**Consultation Response from Mark Berry KC,
Highways Development Management**

2021/93644 Low Farm, Wakefield Road, Flockton, Huddersfield, WF4 4BB

Erection and operation of grid-connected solar photovoltaic farm to supply up to 49.9MW, with ancillary infrastructure and landscaping and biodiversity enhancements

Date Responded: 28-6-2022

Source: GoogleMaps©- Accessed 08/06/2021

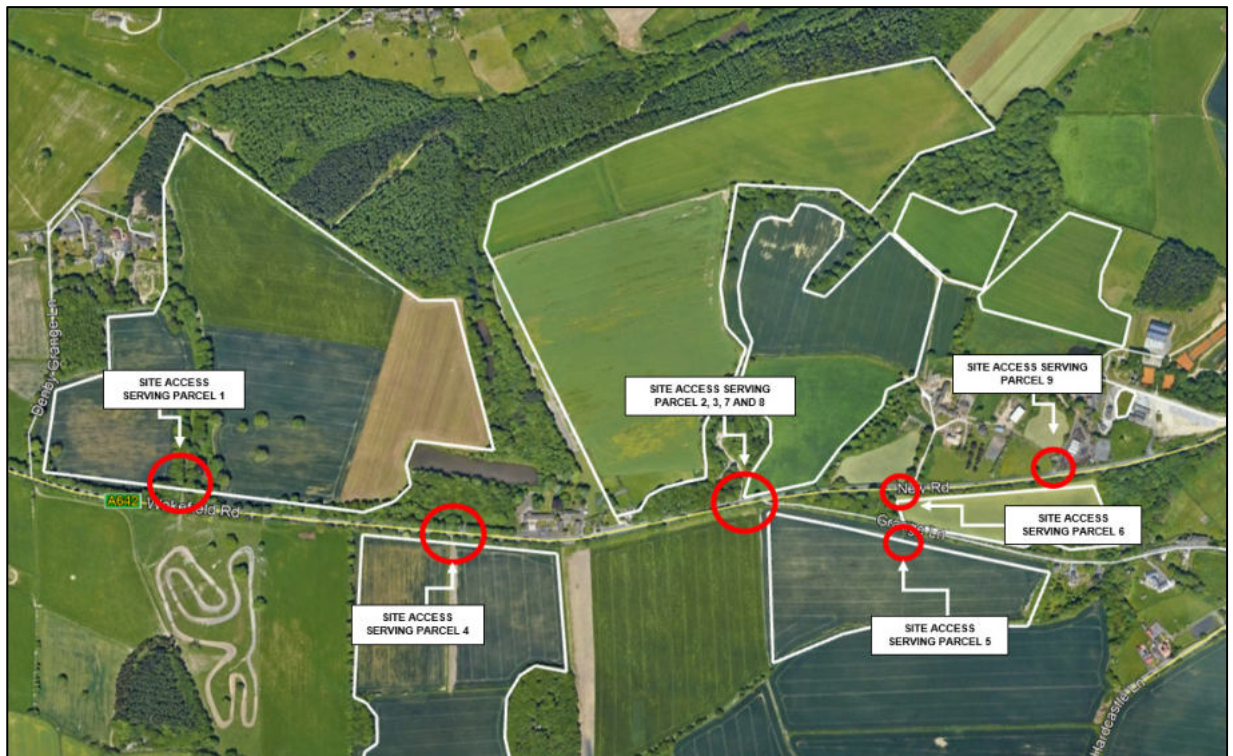
The Highways consultation response dated 27th October 2021 asked the applicants explain why a John Deere Tractor and Rolland Trailer has been tracked for the accesses serving parcels 2 to 8 and not a 16.5 m articulated lorry? The largest vehicle anticipated to use these accesses during the construction period should be tracked.

The applicants have explained that the tracking for a tractor and trailer for parcels 2 to 8 is because this is the type of vehicle which will in fact be used. Large deliveries of materials will be made in the first instance to Parcel 1 where the site compound is located. From there they will be moved where needed around the site by tractor and trailer, and not a 16.5 m articulated lorry.

The anticipated daily tractor and trailer movements from Parcels 1 (and the construction compound) along Wakefield Road to the other Parcels is just 15.

Given the low number of movements along Wakefield Road Highways Development Management have no objection to these proposals
